Consultation Response from: KC Environmental Health (Pollution & Noise Control)		
2020/90441 - Pennine Service Station, Bradley Road, Bradley, Huddersfield HD2 1QD		
Discharge conditions 3, 6, 7, 18 on previous permission 2019/92233 for erection of petrol filling station, including new shop building, canopy, jet-wash and below ground storage tanks		
Date Responded: 07 Jul 2020	Responding Officer: Richard Hume	Responding Ref: WK/202003872
Condition 6 – Artificial lighting scheme Condition 6 states: 6. Development shall not commence on the installation of any external artificial lighting at the site until a scheme which indicates the measures to be taken for the control of any glare or stray light arising from the operation of artificial lighting shall be submitted to and approved in writing by the Local Planning Authority. The scheme should include, but not be limited to, the following information:- • The proposed design level of maintained average horizontal illuminance for the site. • The predicted vertical illuminance that will be caused by lighting when measured at windows of any properties in the vicinity. • The proposals to minimise or eliminate glare from the use of the light

Site 1

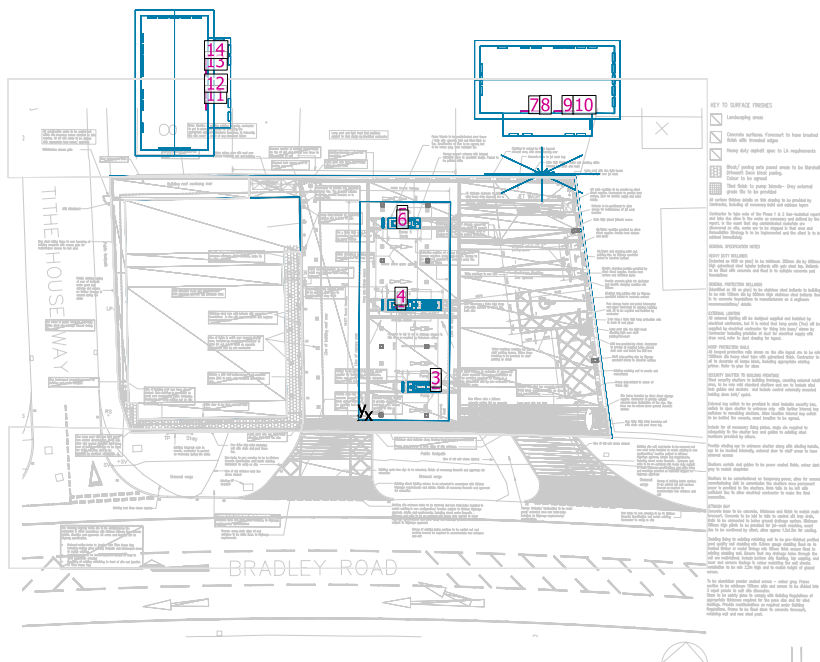
For the reasons detailed above, I recommend that condition should not be discharged at this time.
